CITY OF ALBUQUERQUE

September 29, 2022

**RE: Dutch Bros. Coffee NM0203
Tract 12 of Plat of Tracts 1 through 12 of the Avalon Subdivision Unit 5
Grading and Drainage Plan (K09D048B)
Engineers Stamp Date 6/10/2022**

Job Number  
**22187**  
Sheet  
**C2.0**  
2019 DB  
Franchising USA, LLC

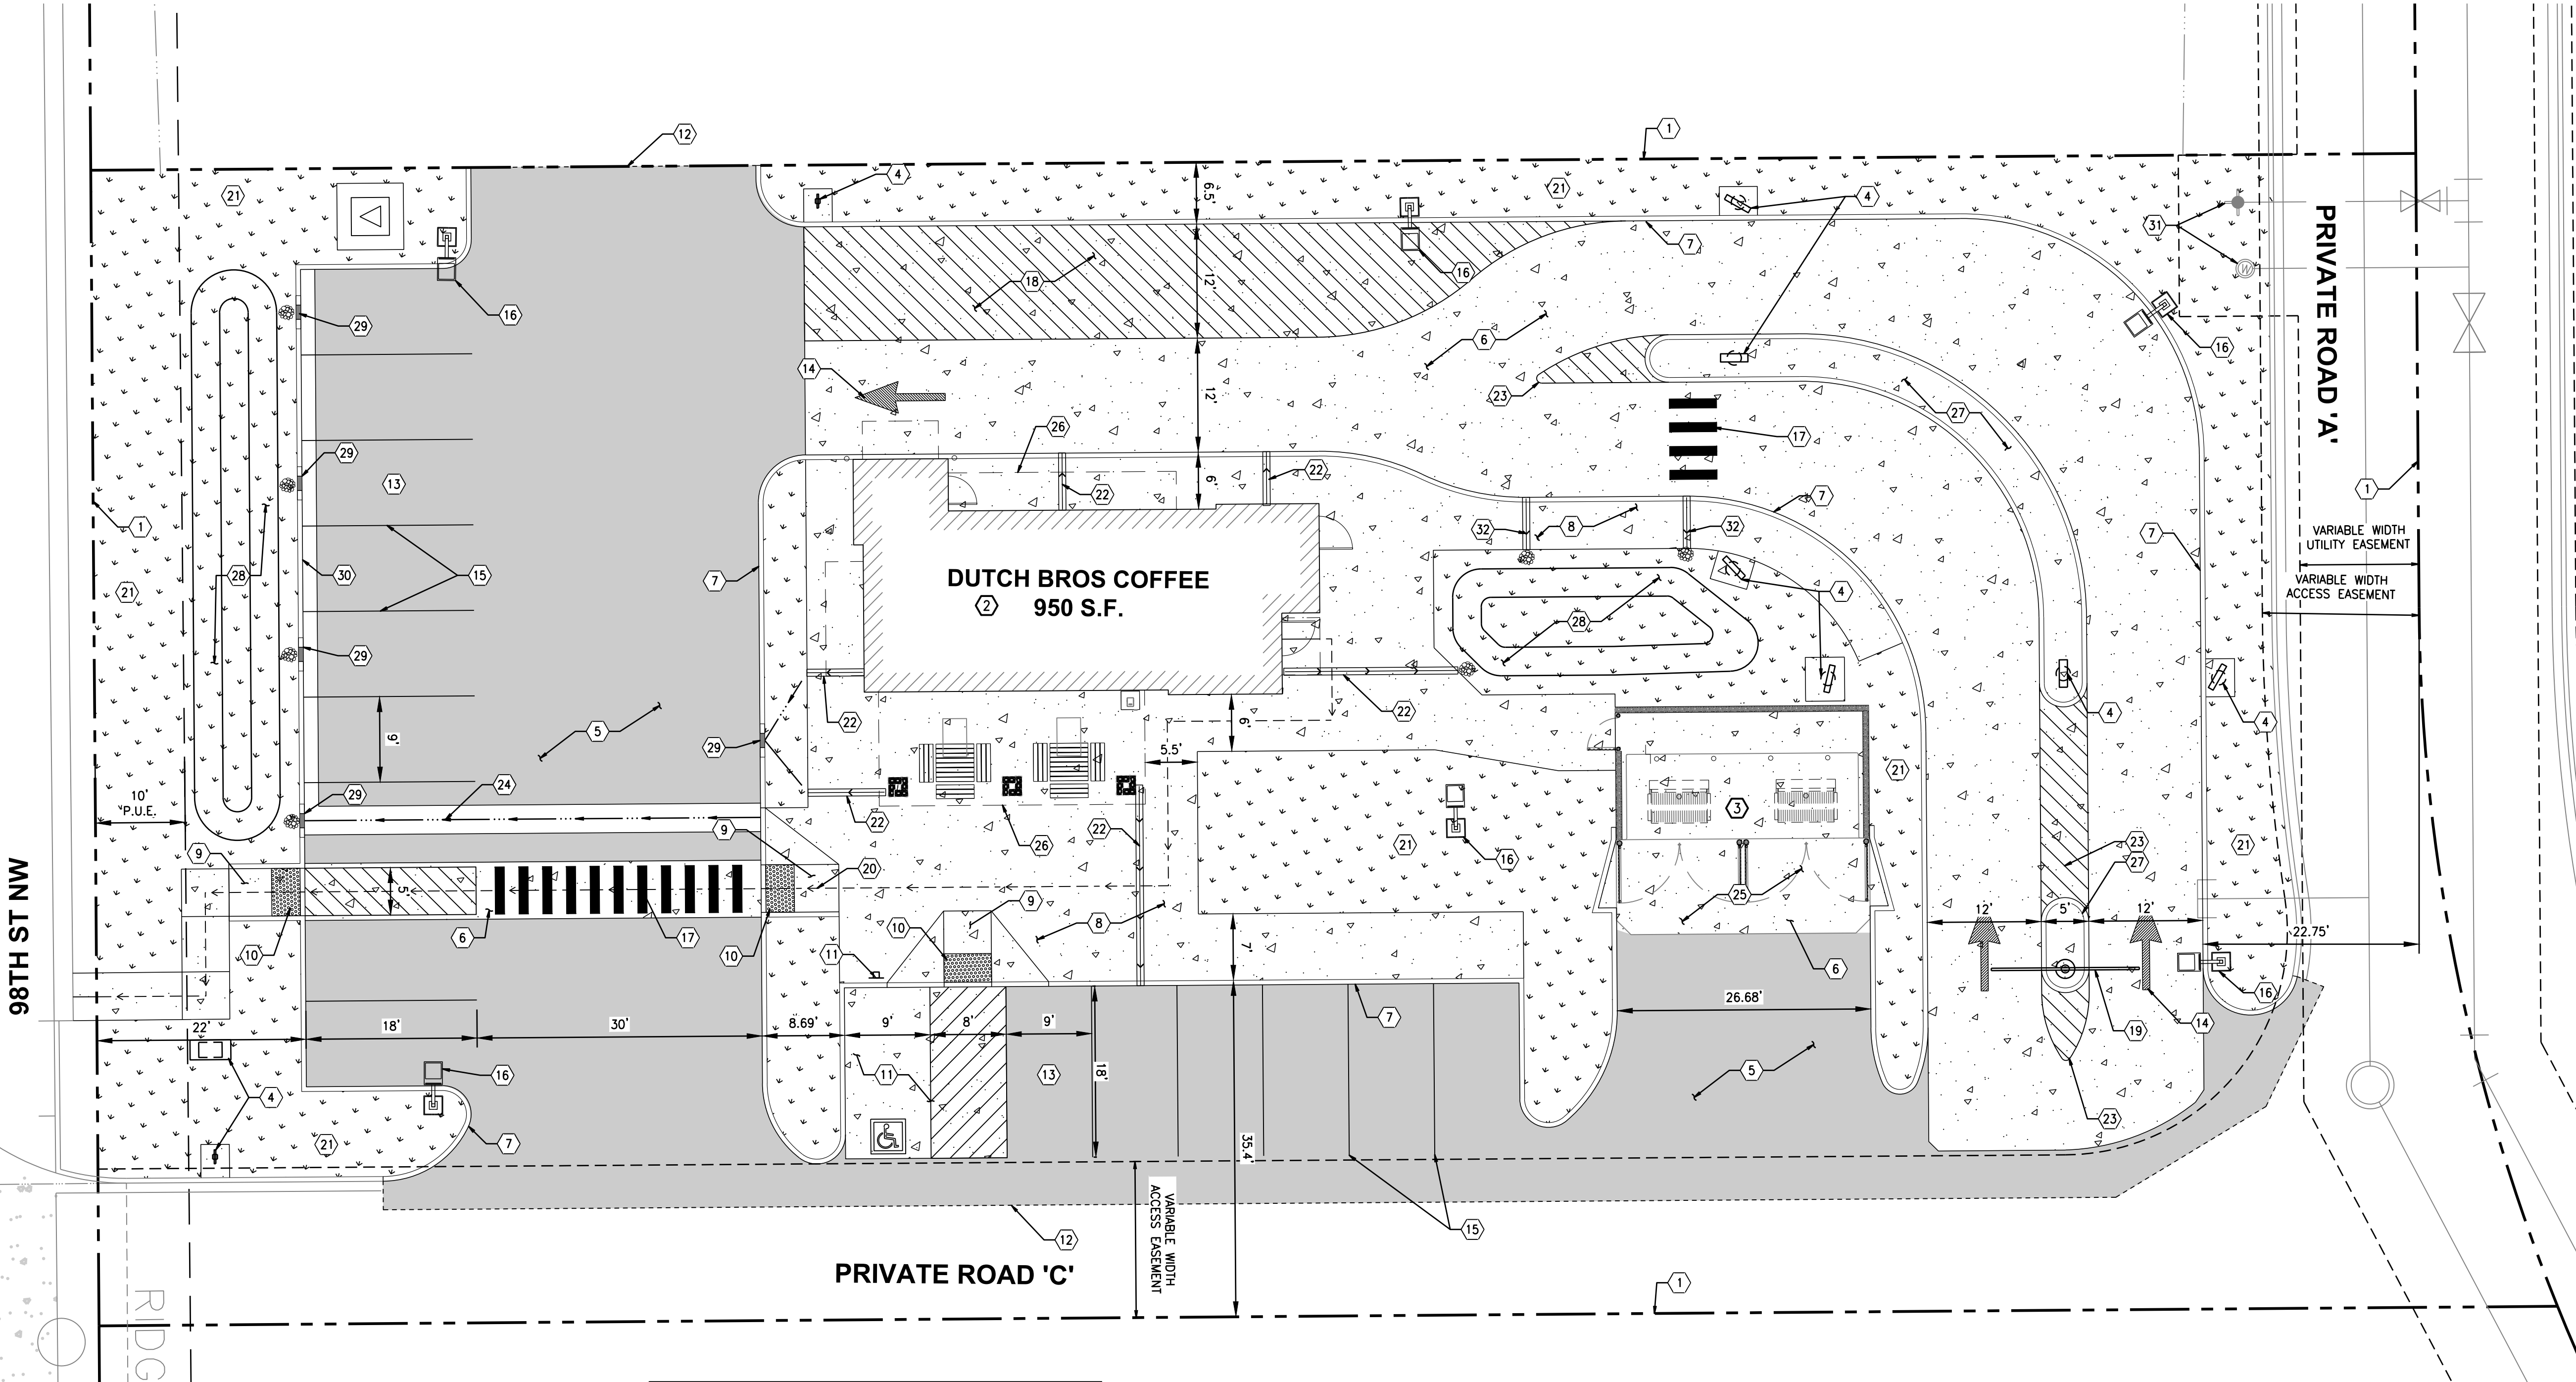
- 1) The site drainage plans must follow the Overall Drainage Plan approved under the City Project Number K09/D048 (http://data.cabq.gov/government/planning/drainage/K09D048/Final/K09D048_GP_Pave_WO_A_PPR.pdf).
- 2) The runoff from this site must be directed to Road A at the discharge rate indicated on the Overall Drainage Plan. Some of the runoff drain to a retention pond to the west.
- 3) Provide runoff calculations to ensure you are not exceeding the allowable discharge.
- 4) The proposed grades must match the grades to the north south and east. To the north the grade is +/- 12" low, to the south the grades are +/-12" higher than Road C grades.
- 5) First Flush Volume must be provided. Please include the required and proposed pond volume calculations.
